Application for a non-material amendment following a grant of planning permission.

2no. rooflights to existing outbuilding to facilitate conversion to home office;
2no rooflights and re-roof existing garage/store to facilitate conversion to home studio;
stable block/tack room; sewage treatment plant; demolition of existing workshop

Reference number:	<input type="text" value="17/01008"/>
-------------------	---------------------------------------

6. Non-Material Amendment(s) Sought

DRAWING No. 001 REV. F

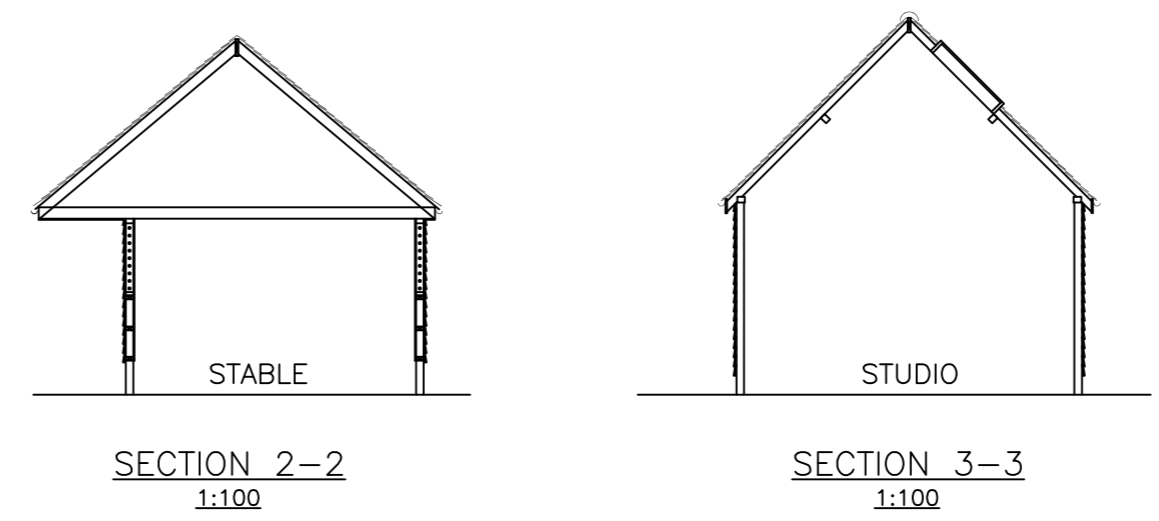
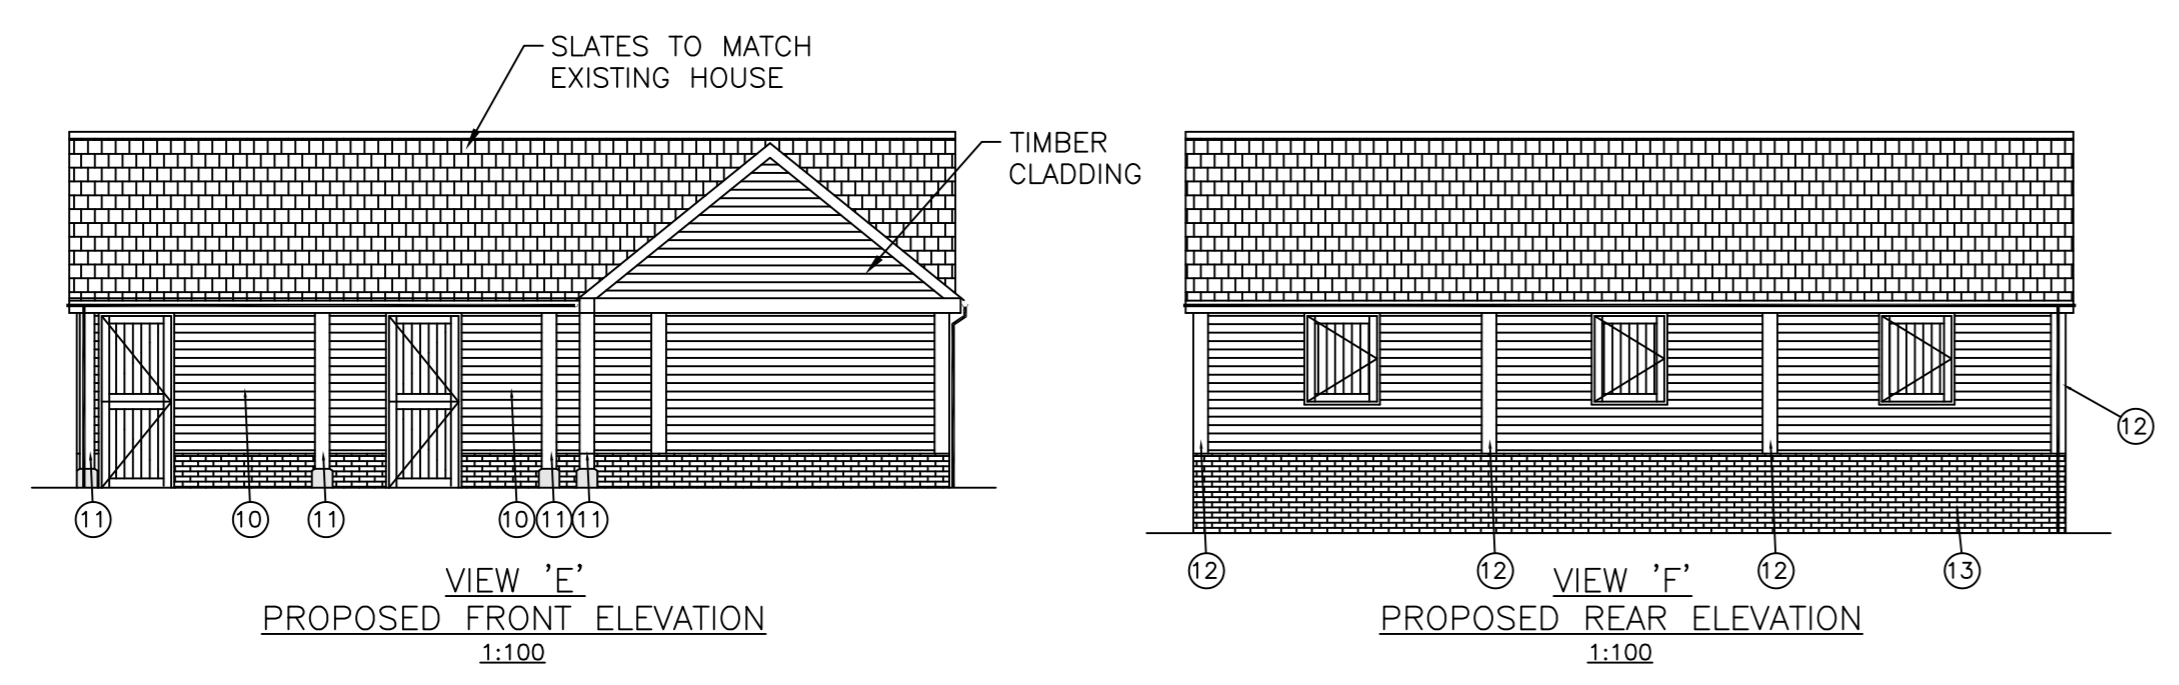
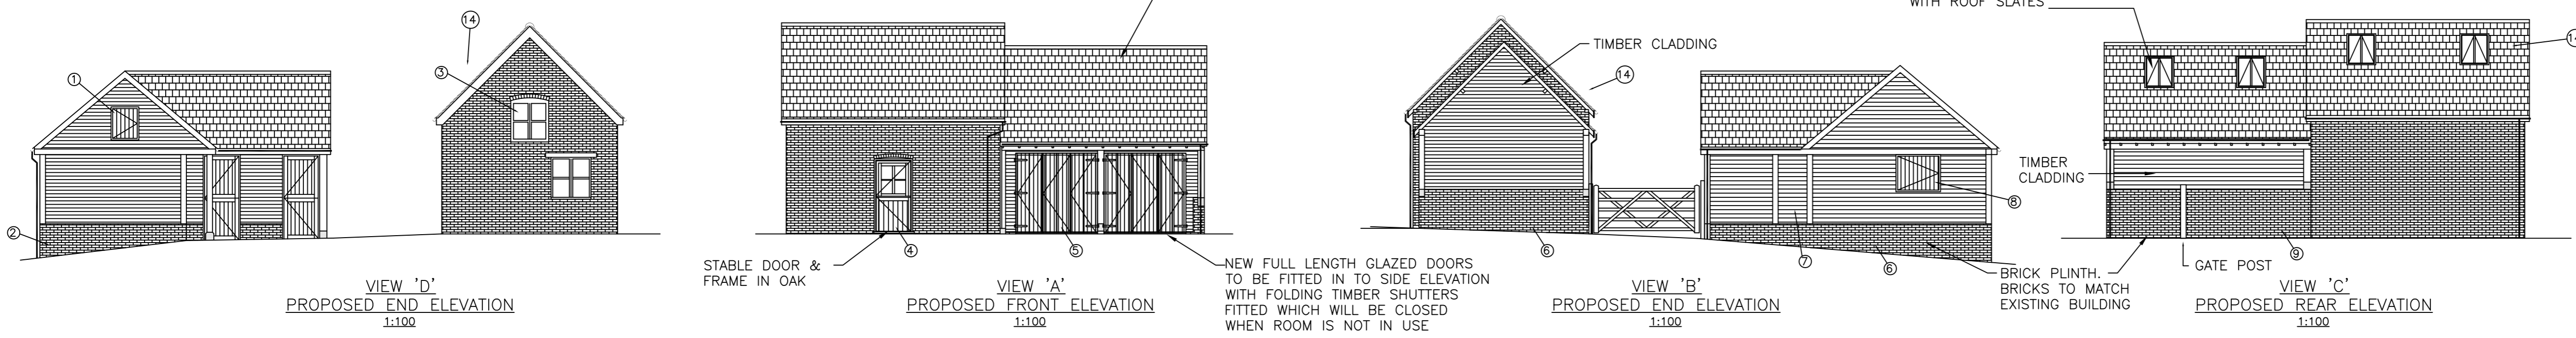
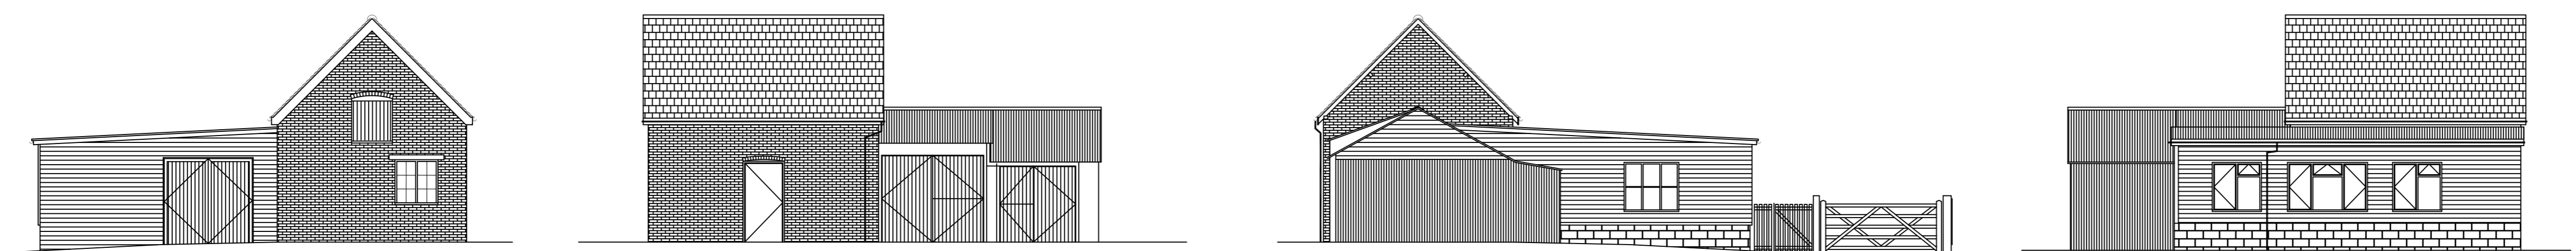
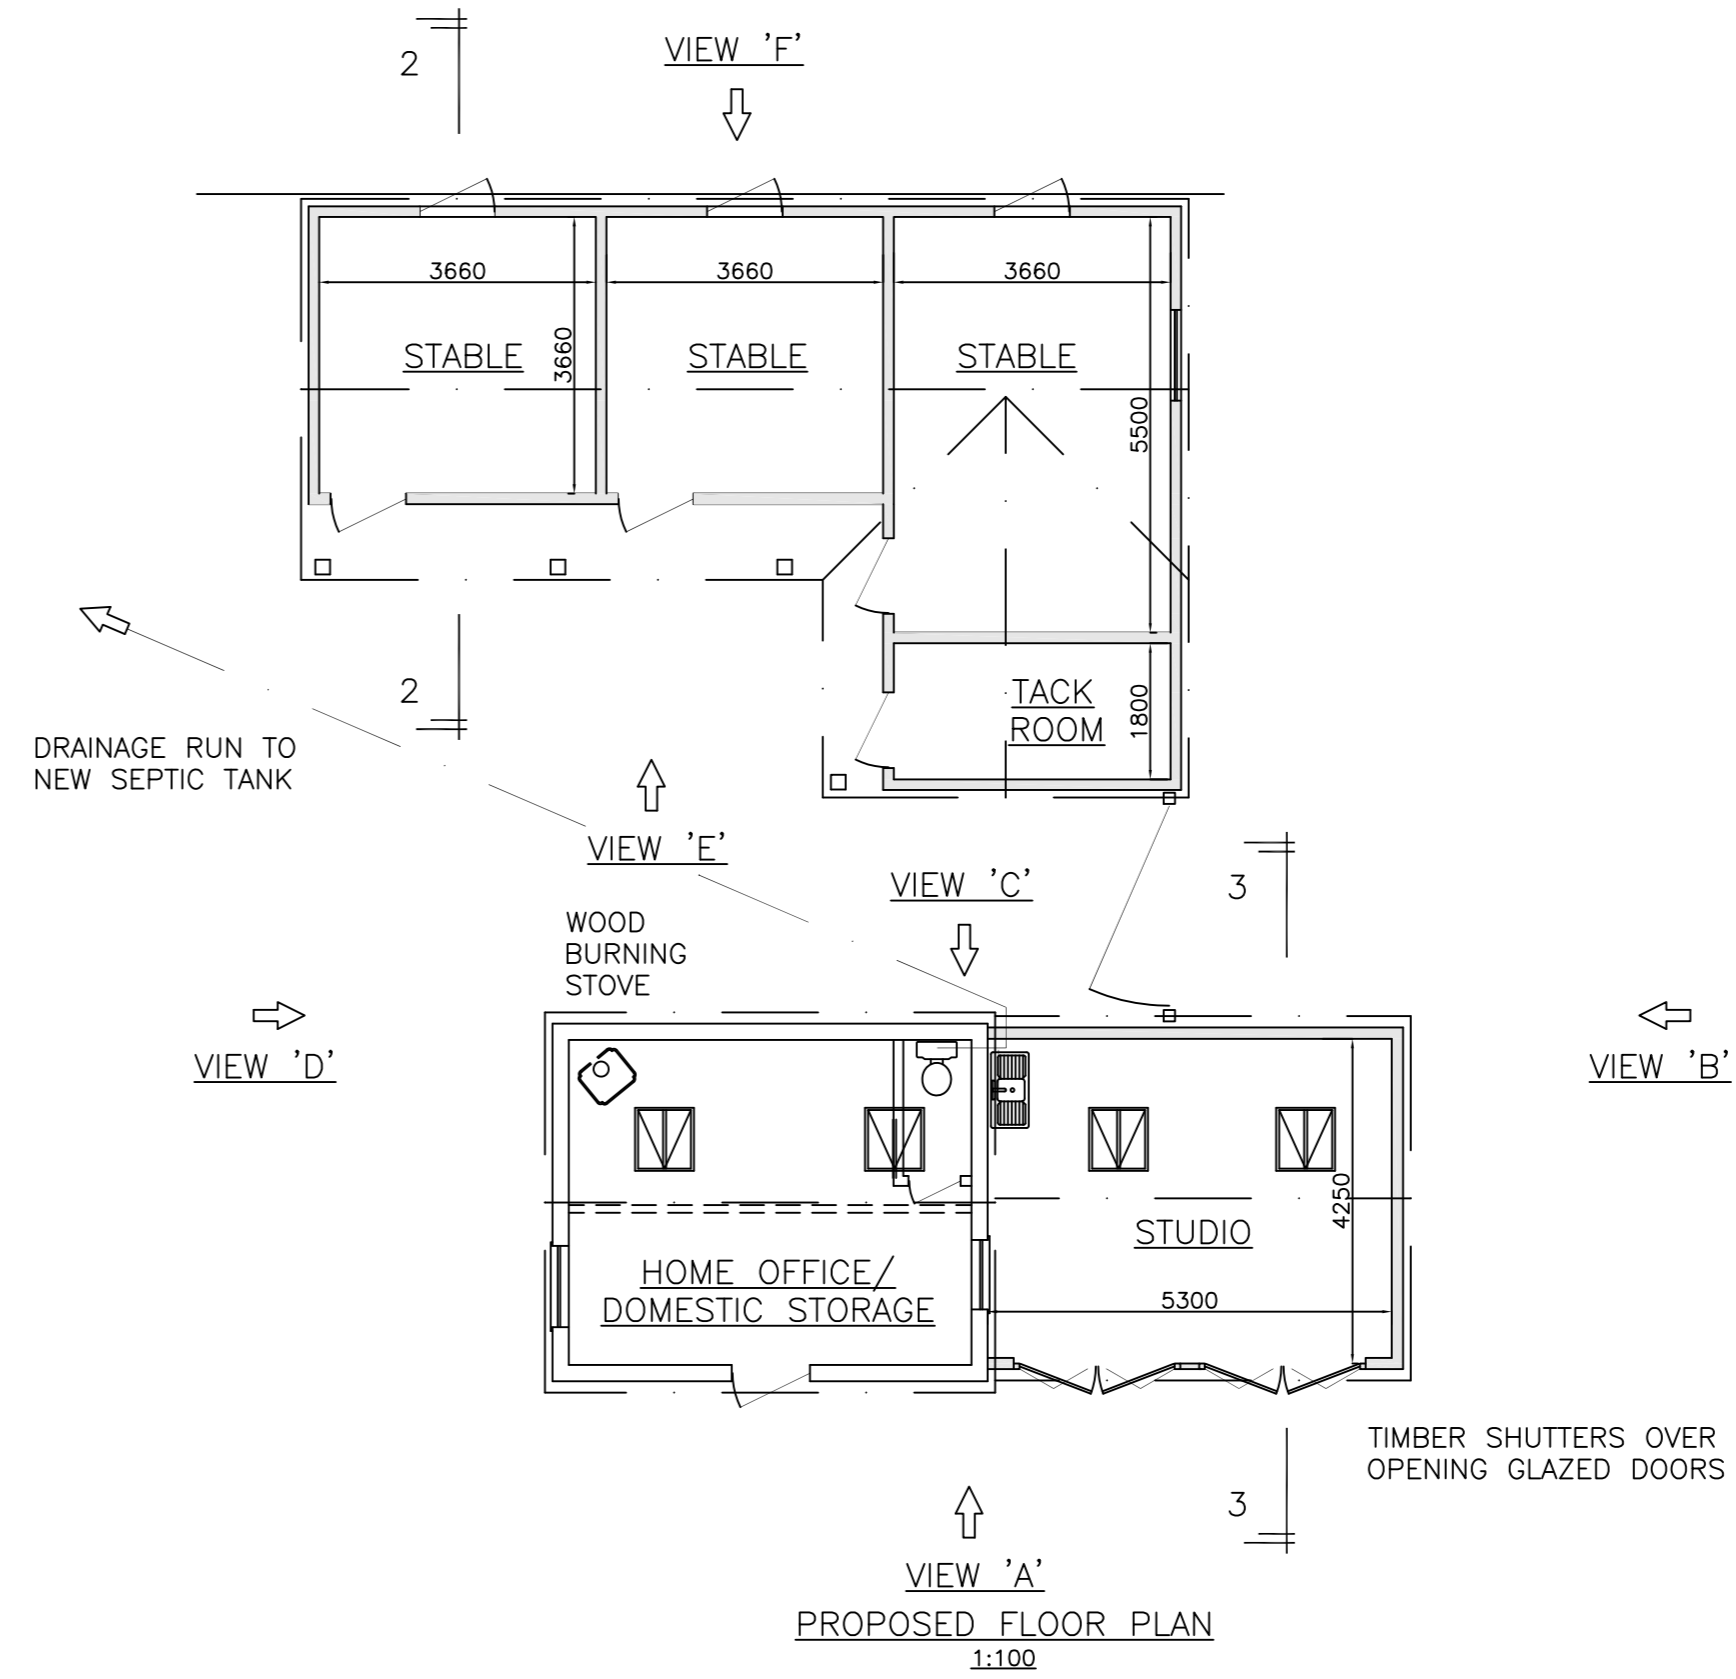
Proposed elevation 'View A' shows oak stable door and frame to home office building and timber folding shutter doors over glazed doors. Proposed elevation 'View B' shows black steel flue removed, higher brick plinth course on home studio and stable building, door removed from stable building, shutter added to stable opening. Proposed elevation 'View C' shows higher brick plinth course and black steel flue removed. Proposed View 'D' shows higher brick plinth course on stable building, shutter added to stable building end opening, unshuttered window to home office, black steel flue removed. Proposed View 'E' shows stable windows removed from stable building and oak posts added. Proposed View 'F' shows higher brick plinth course on stable building and oak posts added.

Drawing 001 Rev F
Drawing 003 Rev B

To accurately reflect the proposed "as built" and the look of the buildings upon completion of the works and to address the issues raised by the enforcement notice Ref QU/21/001.
